From: Simon Davis [mailto:Simon.Davis@arun.gov.uk]
Sent: 08 November 2018 16:39
To: Nick Hebden [REDACTED]
Subject: FW: Planning Consultation on: BR/263/18/PL

APPLICATION BR/263/18/PL

Site Address: St Josephs Albert Road Bognor Regis PO21 1NJ

Description of Works: Application for variation of conditions following grant of planning permission BR/348/16/PL relating to Cond 2 - Block plan & smoking shelter, Cond 9 - smoking shelter materials & Cond 11 - use of smoking shelter & conservatory.

CLIENT Butlins Skyline Ltd.
PROJECT St Josephs
DRAWING TITLE Smoking Shelter

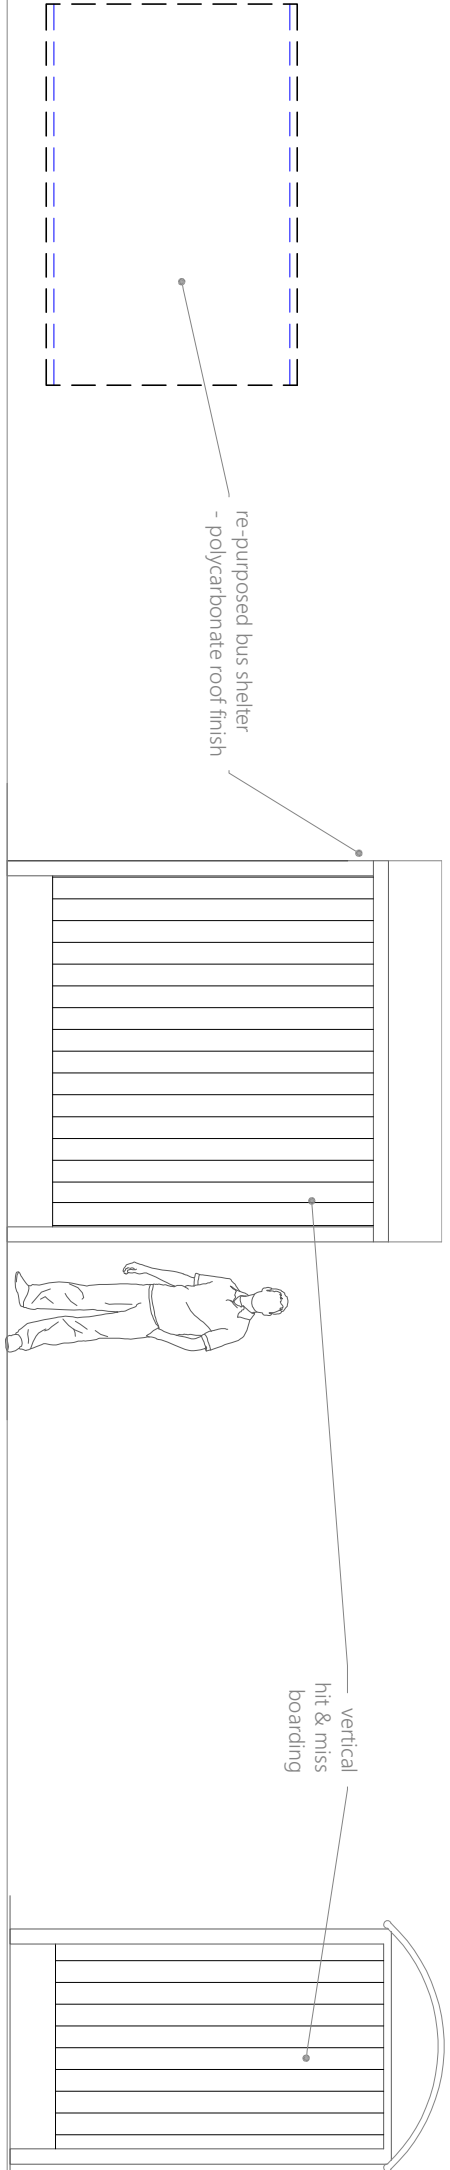
I can confirm that Environmental Health have no objection to the intended increase in the size and location of the smoking shelter provided the time restrictions are still applied (no use between 22.00 and 07.00). I would also request that the western side of the shelter which faces towards the rear of Las Arenas is made of solid construction to reduce noise break out. When constructing the shelter the applicants should note that at least 50% of the shelter construction should be open, so with a roof there should only be one other wall. The other conditions in relation to the shelter should remain.
